People For The Plains

The following is a submission against the Santos Environmental Impact Statement for the Narrabri Gas Project, Application Number SSD 6456.

Figure 7-4 Overview of the water treatment process

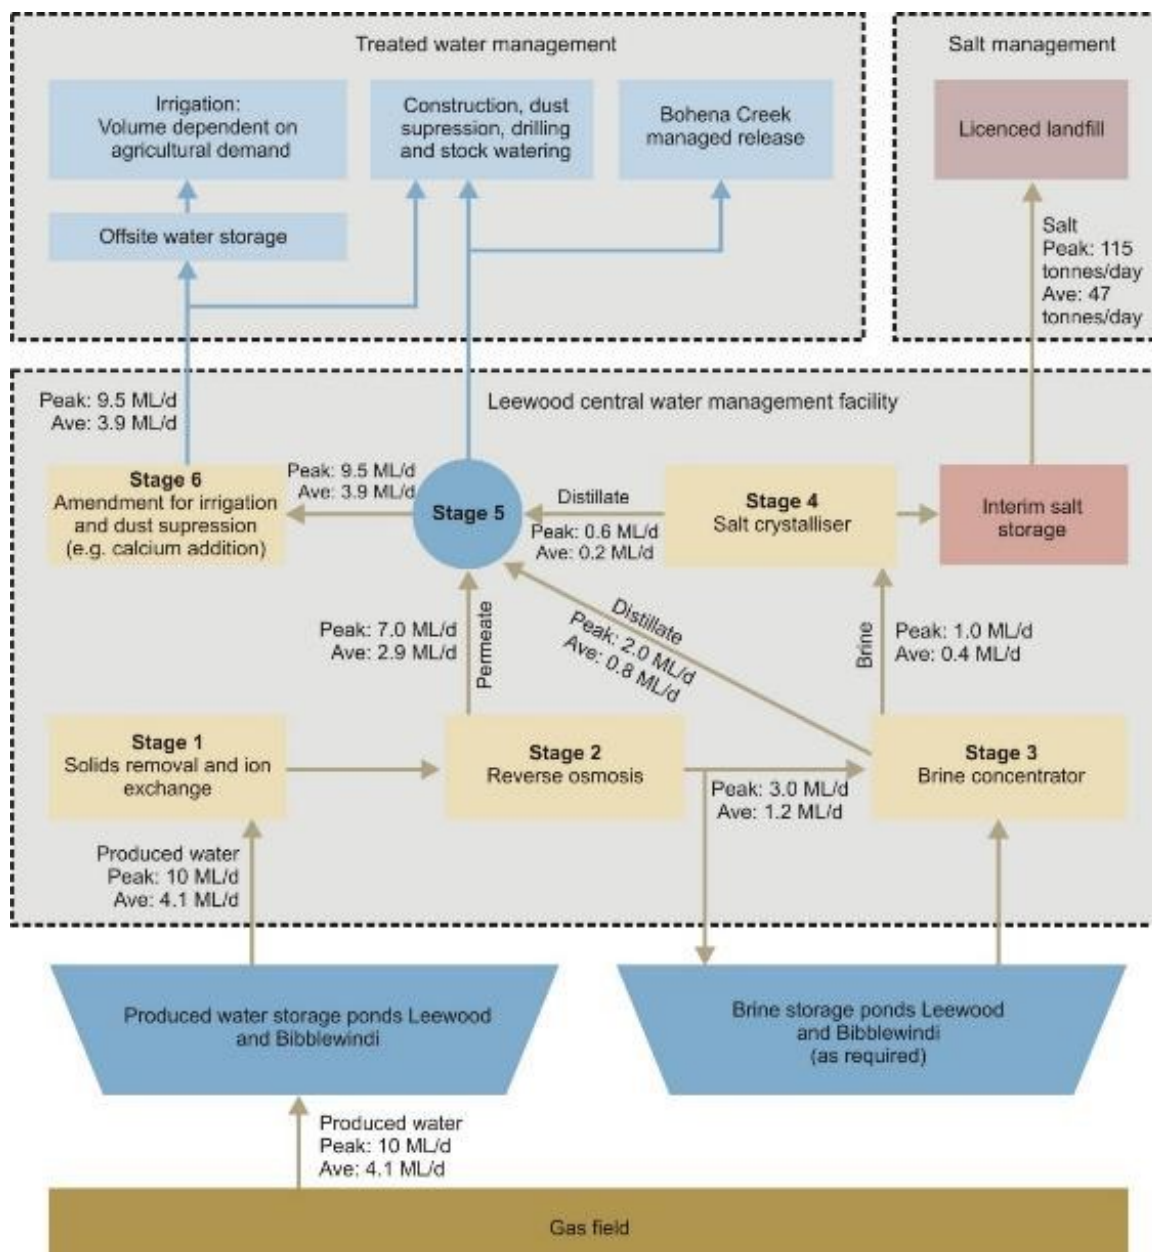
These may be beneficial reuses of the treated water but that treated water has a salts content of almost three (3) times the local natural level, and a sodium level three (3) times the existing natural level, and this calculation is based on the produced water being treated at 25°C and new membranes in the reverse osmosis plant. At 30°C, the treatment temperature, with new membranes in the reverse osmosis plant, the salt content rises to almost sixty-five times the natural level and the sodium content rises to almost five (5) times the natural levels. (These figures are based on the best stock and domestic bore results from within the Pilliga State Forest.)

1. The proposed new ponds at Leewood
2. The actual site of the Irrigated country
3. Soils and drainage information
4. Information on the final gas compression unit
5. Information on the entire produced water treatment plant
6. Information on the brine crystallizer and supporting infrastructure
7. Where the re-classified salts waste will go
